**Attachment A – Detailed response to request for additional information**

Glenwood High School Upgrade – State Significant Development Application

status	scale at A1 1:250	drawn by NKK	checked KEH	rev. I
project no. 6393	drawing no. CV-0201

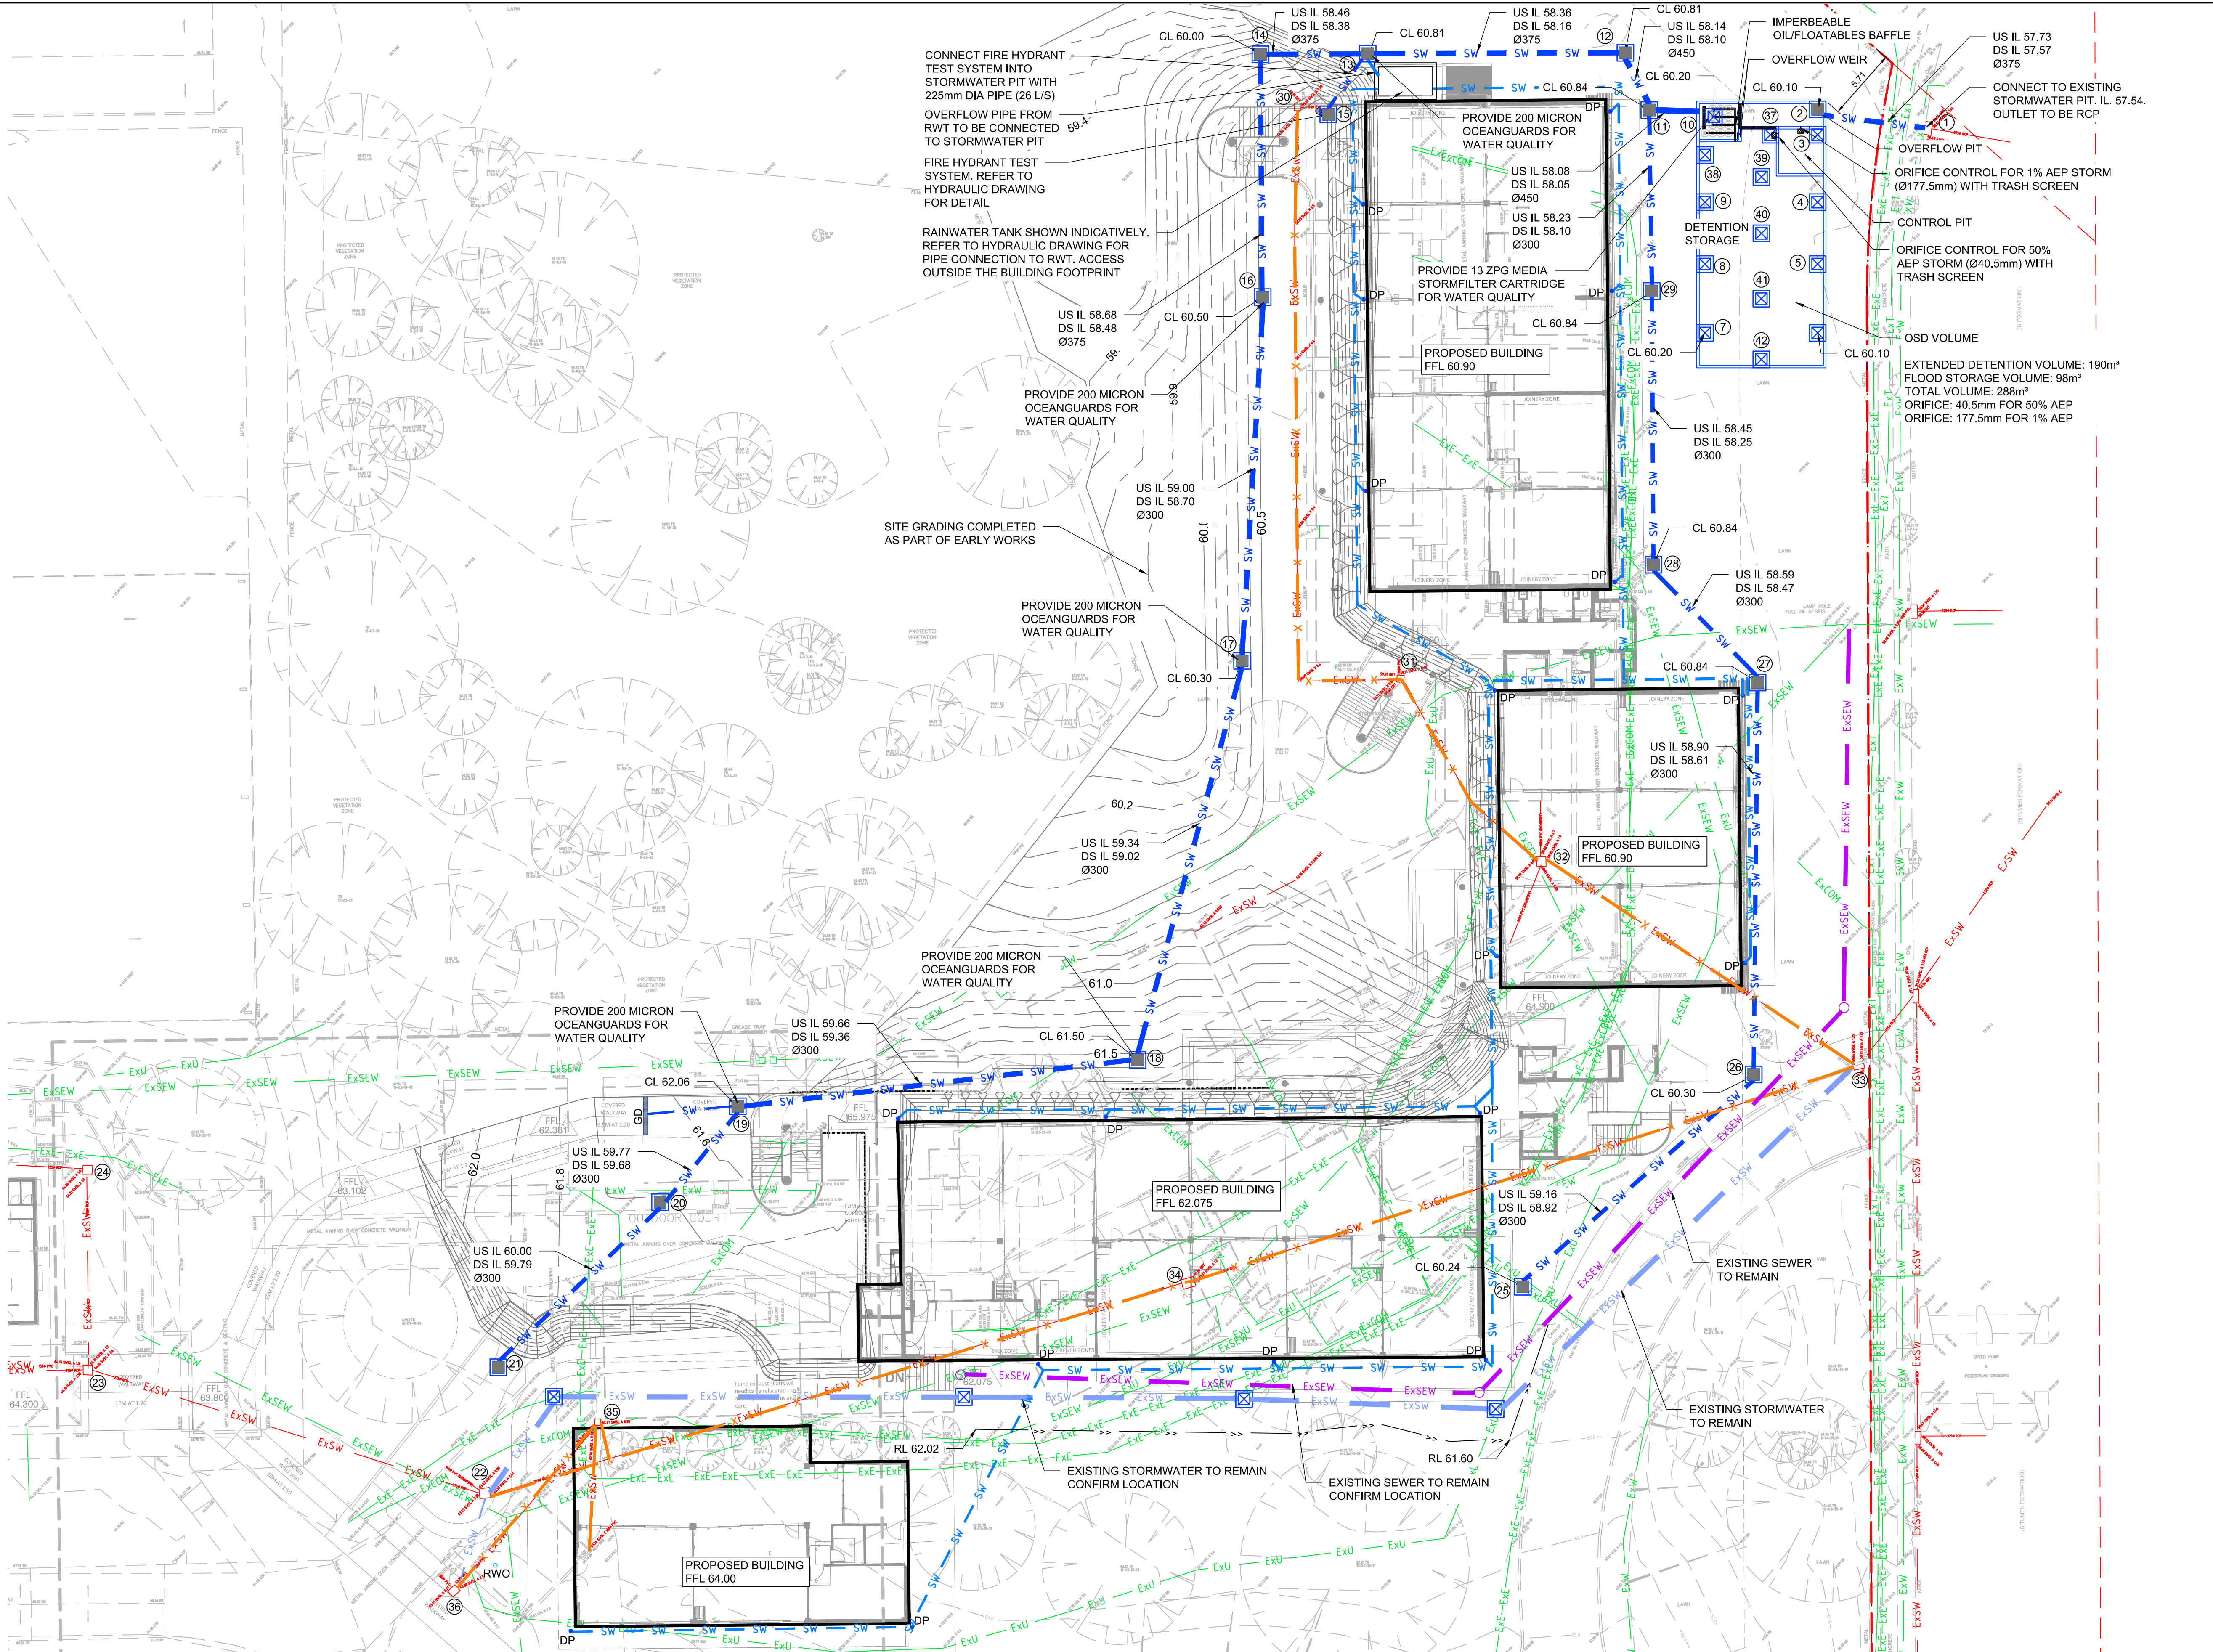
| Issue                                                                                                                                                                                                                                                                                                                                                                                                                                                                                                                                                                                                                                                                                                                                                                                                                                                                                                                                                                                                                                                                                                                                                                             | Response                                                                                                                                                                                                                                                                                                                                                                                                                                                                                                                                                                                                                                                                                                                                                                                                                                                                                                                                                                                                                                                                                                                                                                                                                                                                                                                                                                                                                                                                                                                                                                                                                                                                                                                                                                                |
|-----------------------------------------------------------------------------------------------------------------------------------------------------------------------------------------------------------------------------------------------------------------------------------------------------------------------------------------------------------------------------------------------------------------------------------------------------------------------------------------------------------------------------------------------------------------------------------------------------------------------------------------------------------------------------------------------------------------------------------------------------------------------------------------------------------------------------------------------------------------------------------------------------------------------------------------------------------------------------------------------------------------------------------------------------------------------------------------------------------------------------------------------------------------------------------|-----------------------------------------------------------------------------------------------------------------------------------------------------------------------------------------------------------------------------------------------------------------------------------------------------------------------------------------------------------------------------------------------------------------------------------------------------------------------------------------------------------------------------------------------------------------------------------------------------------------------------------------------------------------------------------------------------------------------------------------------------------------------------------------------------------------------------------------------------------------------------------------------------------------------------------------------------------------------------------------------------------------------------------------------------------------------------------------------------------------------------------------------------------------------------------------------------------------------------------------------------------------------------------------------------------------------------------------------------------------------------------------------------------------------------------------------------------------------------------------------------------------------------------------------------------------------------------------------------------------------------------------------------------------------------------------------------------------------------------------------------------------------------------------|
| <p>v. On drawing 0201 (A):</p> <p>a) <i>It seems all the roof water is bypassing the rainwater tank and discharging directly into the stormwater line. Show how the roof water gets to the rainwater tank. Provide a separate system for roof water and surface drainage. Pits between the roof lines (i.e. charged pipes) are to be sealed.</i></p> <p>b) <i>Provide details of the rainwater tank including pre-treatment, volumes, sections, dimensions etc.</i></p> <p>c) <i>The 375 mm diameter outlet to the existing stormwater Pit 1 is to be RCP.</i></p> <p>d) <i>Provide levels of the existing street Pit 1 and confirm the connection level to this pit.</i></p> <p>e) <i>Clearly show details of all pits including surface levels and invert levels.</i></p> <p>f) <i>It is unclear whether Pits 18 and 27 are treating surface flows and all or only part of the upstream pipe flows as well. Provide detail for Pit 18 and 27 showing all invert levels for all pipes.</i></p> <p>g) <i>OceanGuards should treat a maximum of 1000 m2 of non-roof areas and 1500m2 of roof areas. All OceanGuards are to be clearly notated as "200 micron OceanGuards".</i></p> | <p>g) All roof areas, as shown on 0201 are directed to the Rainwater Tank for cleaning and reuse. It is confirmed that non roof area draining to pits have an area no greater than 1000m<sup>2</sup>.</p> <p>Moreover, OceanGuard notations are shown on drawing CV-0201. Oceanguard detail noted on drawing CV-0212 as 200 microns. Refer to report section 6.1.2 for Oceanguard reference.</p> <p>h) Pipe invert and pit levels provided on drawing CV-0201 which indicates the oceanguard pit baskets are above the connecting pipes.</p> <p>i) Pipe invert and pit levels provided on drawing CV-0201 which indicates the oceanguard pit baskets are above the connecting pipes.</p> <p>j) Oceanguard detail now provided on drawing CV-0212. Refer to report section 6.1.2 for more details on the oceanguard.</p> <p>vi. Drawing 0213(A) has been amended as follows:</p> <p>a) These pipe sizes are correct. Pipe decreases as we are slowing the water flows from the property as required by Blacktown City Council 'Engineering Guide for Development – 2005'. A DRAINS model provided for review at <b>Attachment D</b>. Should the tank block, discharge is directly to the street. Maximum flow rate will be dependent on tank in flow rate.</p> <p>b) OSD tank design shown on drawing CV-0212 has revised to meet the OSD Deemed to Comply Tool Spreadsheet. The spreadsheet is provided for review at Appendix B of the Report and <b>Attachment F</b>.</p> <p>c) Drawing 0213 has been updated with 100mm false floor, baffle distance, and operation with a sealed lid.</p> <p>d) Drawing 0213 has been updated with 100mm false floor, baffle distance, and operation with a sealed lid.</p> <p>e) Dimensions added to Drawing CV-0213 indicating chamber sizes.</p> |

| Issue                                                                                                                                                                                                                                                                                                                                                                                                                                                                                                                                                                                                                                                                                                                                                                                                                                                                                                                                                                                                                                                                                                                                                                                                                                                                                                | Response |
|------------------------------------------------------------------------------------------------------------------------------------------------------------------------------------------------------------------------------------------------------------------------------------------------------------------------------------------------------------------------------------------------------------------------------------------------------------------------------------------------------------------------------------------------------------------------------------------------------------------------------------------------------------------------------------------------------------------------------------------------------------------------------------------------------------------------------------------------------------------------------------------------------------------------------------------------------------------------------------------------------------------------------------------------------------------------------------------------------------------------------------------------------------------------------------------------------------------------------------------------------------------------------------------------------|----------|
| <p>rooms and does not impact adjacent properties.</p> <p>b) <i>The design levels in the OSD tank do not match the S3QM Certificate Results or the OSD Deemed to Comply Tool Spreadsheet. Ensure consistency between the design.</i></p> <p>c) <i>Provide more details for the Stormfilter tank such as false floor level and thickness, impermeable baffle distance upstream of Stormfilter weir etc.</i></p> <p>d) <i>Provide details of how the overflow chamber will operate with the sealed lid.</i></p> <p>e) <i>On the tank plan view, provide separate dimensions for the OSD tank and Stormfilter Chamber.</i></p> <p>f) <i>Provide a sealed impermeable baffle, or hood set 250 mm upstream of the Stormfilter weir and extending from the sealed underside of the tank to 400 mm below the top of the weir for the 690 mm Stormfilter cartridge to contain floatables including oil. The Stormfilter weir level is to be set 770 mm above the false floor.</i></p> <p>g) <i>The minimum length of the Stormfilter weir (L) is to be increased to provide a maximum velocity of 0.4 m/s under the baffle during peak flow (i.e. <math>L &gt; Q100 / (0.4 \times 0.25)</math>, or <math>L &gt; 10 \times Q100</math>) in m, where Q100 is in m<sup>3</sup>/s). Provide calculations.</i></p> |          |

| Issue                                                                                                                                                                                                                                                                                                                                                                                                                                                                                                                                                                                                                                                                                                                                                                                                                                                                                                                                                                                                                                                                                                                                                                                                                                                                                                          | Response                                                                                                                                                                                                                                                                                                                                                                                                                                                                                                                                                                                                                                                                                                                                                                                                                                                                                                                                                                                                                                                                                                                                                                                                                                                                                                                                                                                                                                                                                                                                                                                                                                                                                                                                                                                                                                                                                                                                                                                                            |
|----------------------------------------------------------------------------------------------------------------------------------------------------------------------------------------------------------------------------------------------------------------------------------------------------------------------------------------------------------------------------------------------------------------------------------------------------------------------------------------------------------------------------------------------------------------------------------------------------------------------------------------------------------------------------------------------------------------------------------------------------------------------------------------------------------------------------------------------------------------------------------------------------------------------------------------------------------------------------------------------------------------------------------------------------------------------------------------------------------------------------------------------------------------------------------------------------------------------------------------------------------------------------------------------------------------|---------------------------------------------------------------------------------------------------------------------------------------------------------------------------------------------------------------------------------------------------------------------------------------------------------------------------------------------------------------------------------------------------------------------------------------------------------------------------------------------------------------------------------------------------------------------------------------------------------------------------------------------------------------------------------------------------------------------------------------------------------------------------------------------------------------------------------------------------------------------------------------------------------------------------------------------------------------------------------------------------------------------------------------------------------------------------------------------------------------------------------------------------------------------------------------------------------------------------------------------------------------------------------------------------------------------------------------------------------------------------------------------------------------------------------------------------------------------------------------------------------------------------------------------------------------------------------------------------------------------------------------------------------------------------------------------------------------------------------------------------------------------------------------------------------------------------------------------------------------------------------------------------------------------------------------------------------------------------------------------------------------------|
| <p><u>Key Drainage Issues</u></p> <p>1. <i>Civil Engineering Design Report by Enstruct Group Pty Ltd project no. 6393 revision C dated 9 November 2021 and Stormwater Management Plans in Appendix D of Civil engineering Design Report project no. 6393 revision a dated 9 November 2021:</i></p> <ul style="list-style-type: none"> <li>i. <i>Provide OSD catchment plan demonstrating which areas drain to the OSD and areas bypassing.</i></li> <li>ii. <i>Provide a MUSIC catchment plan that shows both the land use and the areas contributing to each specific device. To make this more understandable it may be easier in many cases to split these into two separate plans. Include all bypassing catchments.</i></li> <li>iii. <i>The 1% AEP flows from the site are to be directed to the OSD. Demonstrate how the surface flows in excess of the pipe capacity are directed to the OSD system.</i></li> <li>iv. <i>The OSD Deemed to Comply Tool Spreadsheet levels do not match the OSD design and also includes incorrect design details for the proposed Filter Cartridges. The spreadsheet is to be amended to include correct Design Filter Cartridge Flows and Filter Cartridges flows with 1% AEP HED. Ensure details and levels are reflected in the design subsequently.</i></li> </ul> | <p>1. A revised Civil Engineering Design Report has been prepared by enstruct (found at <b>Attachment C</b>) which addresses the below items:</p> <ul style="list-style-type: none"> <li>i. A catchment plan drawing has been added to Appendix B of the Civil Engineering Design Report (Drawing No. CV-0200). This plan shows catchment areas which drain to the OSD.</li> <li>ii. The catchment plan drawing (Drawing No. CV-0200) shows catchment areas identical to the MUSIC model.</li> <li>iii. The 1% AEP flows are piped to the OSD tank. A DRAINS model is provided for review at <b>Attachment D</b>. Furthermore, the catchment plan drawing (Drawing No. CV-0200) shows catchment areas draining to the OSD system.</li> <li>iv. The OSD and stormwater management plans in Appendix C of the Report have been changed to suit the deemed to comply requirements. Refer to Appendix B of the Revised Design Report and the OSD deemed to comply tool spreadsheet at <b>Attachment F</b> for these requirements.</li> <li>v. Drawing 0201(A) has been amended as follows: <ul style="list-style-type: none"> <li>a) Downpipe locations are shown on drawing CV-0201. Downpipes collect and discharge into the proposed rainwater tank. The pipes from the roof are separate to the in-ground stormwater system.</li> <li>b) Rainwater tank volumes added to the Civil Report. Pre-treatment information is also referenced in the revised Civil Report. Refer to Section 6.1.</li> <li>c) A 375mm diameter pipe is noted as RCP on drawing CV-0201.</li> <li>d) Existing Pit 1 and connecting pipe level information added to drawing CV-0201.</li> <li>e) Drawing 0201 now shows stormwater pipe inverts and pit levels.</li> <li>f) Catchment plan CV-0200 has now been included. Pits grate size and type have been upgraded to suit the catchment plan. Refer to pit size schedule on CV-0001. Furthermore, invert levels for all pipes have been shown on drawing CV-0201.</li> </ul> </li> </ul> |
